Martin Nugent
01254 828060
D3/12/0565

Drafted 23 July 2012

**Planning Application, Ribble Valley District
3/12/0565 George Street, Clitheroe**

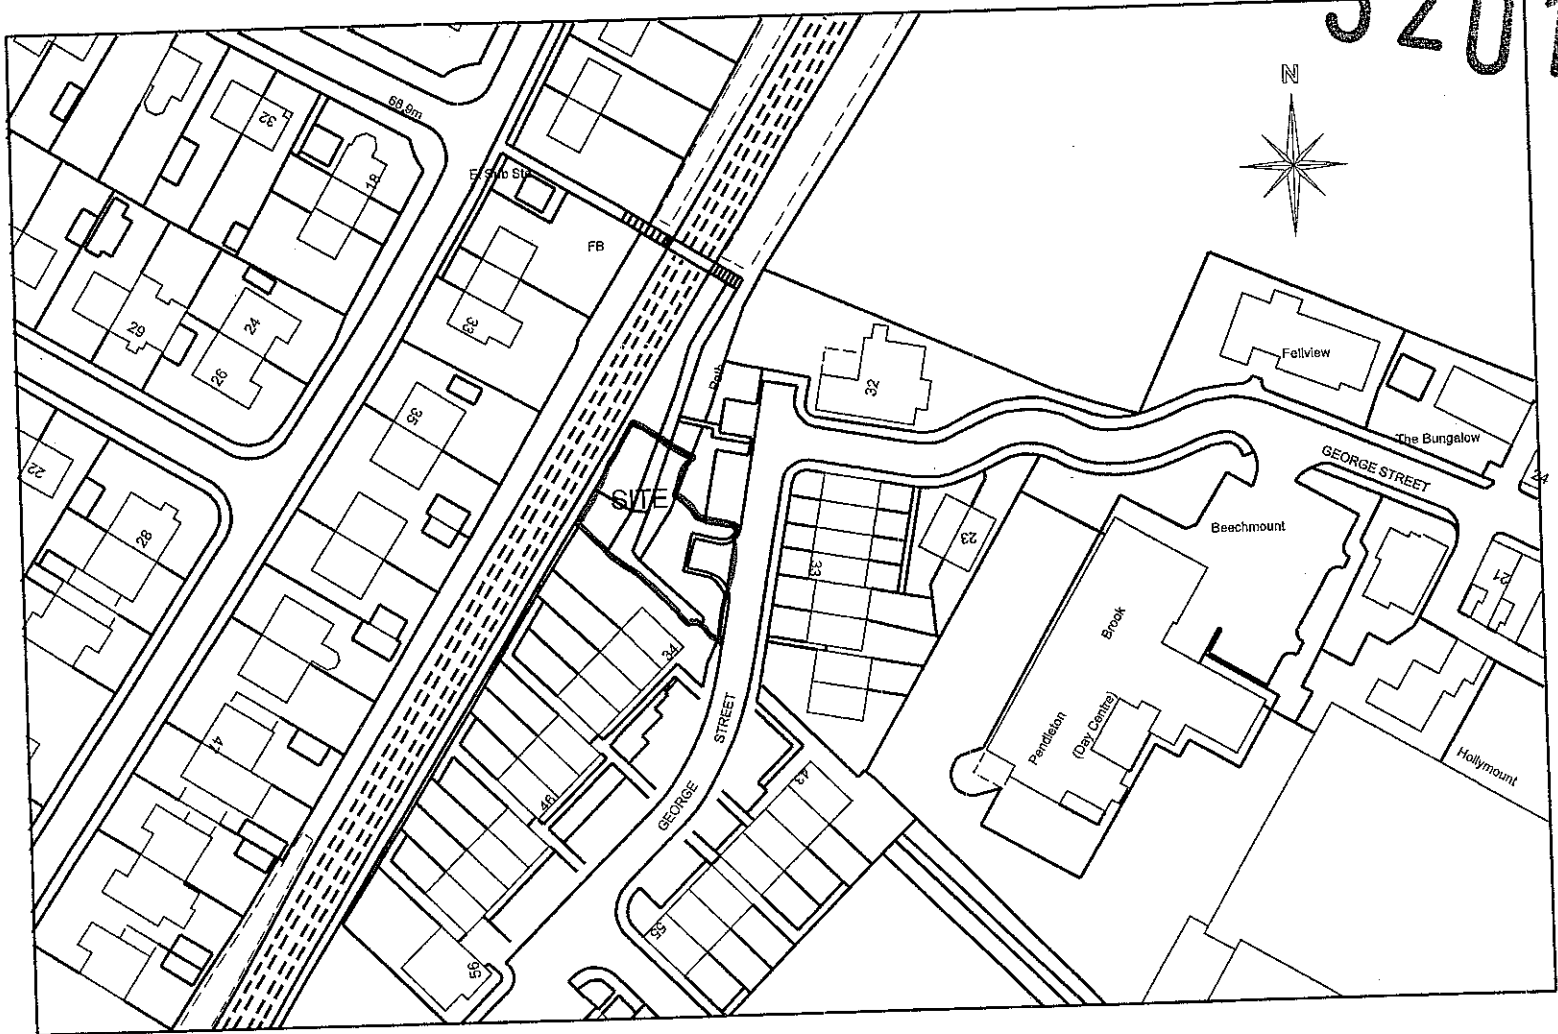
The recent development of affordable units on George Street has resulted in additional highway space being created, within which vehicles can manoeuvre, therefore removing the necessity for the existing turning head.

The off street parking provisions are appropriate for the suggested house type and ownership. However, the applicant will have to discuss with my street lighting colleagues the relocation and recharge of costs relating to the lighting column
